**KIRKLEES METROPOLITAN COUNCIL
INVESTMENT & REGENERATION SERVICE**

DELEGATED DECISION TO DETERMINE PLANNING APPLICATIONS

Reference No: 2018/62/92885/E
Site Address: 16, Howard Place, Batley, WF17 6AB
Description: Erection of single storey front and rear extensions
Recommending Officer: Jennifer Booth

DECISION - REFUSE

PROPOSED FRONT

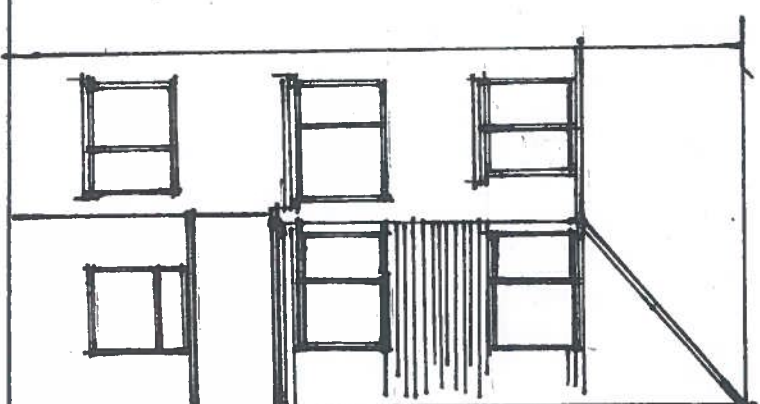
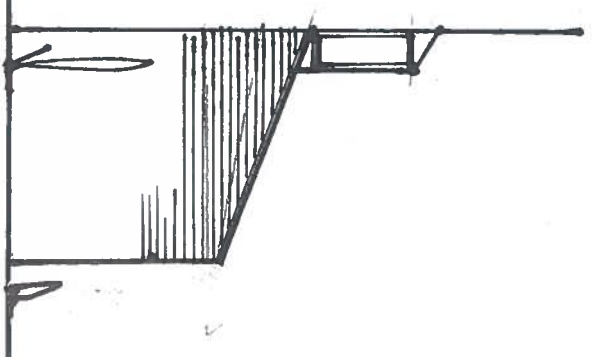
Policy BE14 does support front extension providing it is modest. In this instance, with the 3m projection proposed, the proposed front extension would not be considered to be small in scale. As such and despite the use of matching materials, the front extension would result in the formation of an incongruous feature within the street scene and would therefore not be considered to be acceptable in terms of visual amenity.

Having taken the above into account, the proposed front extension, given its size, would form an incongruous feature within the street scene which would be harmful in terms of visual amenity for both the host dwelling and the wider street scene and has not addressed the previous reason for refusing a recent application. The proposals, in relation to the front extension, therefore fail to comply with Policies D2, BE1, BE13 and BE14 of the UDP, Policy PLP24 of the PDLF and the aims of chapter 12 of the NPPF.

1. The proposed front extension, by reason of its design and scale, would result in the formation of an incongruous feature within the street scene contrary which would be harmful in terms of the character of the host property and the wider street scene. To permit such an extension would be significantly harmful to visual amenity and contrary to Policies D2, BE1, BE13 and BE14 of the Kirklees Unitary Development Plan, Policy PLP24 of the Kirklees Publication Draft Local Plan and Chapter 12 of the National Planning Policy Framework.

PROPOSED REAR

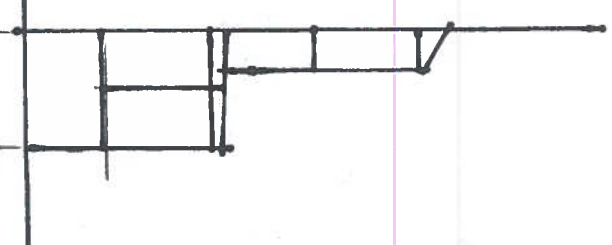
The proposed rear extension would be constructed using matching materials and although it would cover most of the rear yard of the dwelling, the land to the rear of the dwelling is very open and as such the proposed extension would not amount to overdevelopment. As such, this element of the scheme is considered to be acceptable in terms of visual amenity.

The proposed rear extension would be constructed along the common boundary with the adjoining property and would have the potential to form an overbearing feature with some overshadowing in the evening. However, the extension is single storey with a projection of 3m which is in line policy BE14. It is considered therefore that any impact on the amenities of the occupiers of the adjoining property, 14 Howard Place would be limited.

The proposed rear extension would be constructed along the common boundary with the adjoining property and would have the potential to form an overbearing feature with some overshadowing in the morning. However, the extension is single storey with a projection of 3m which is in line policy BE14. It is considered therefore that any impact on the amenities of the occupiers of the adjoining property, 18 Howard Place would be limited.
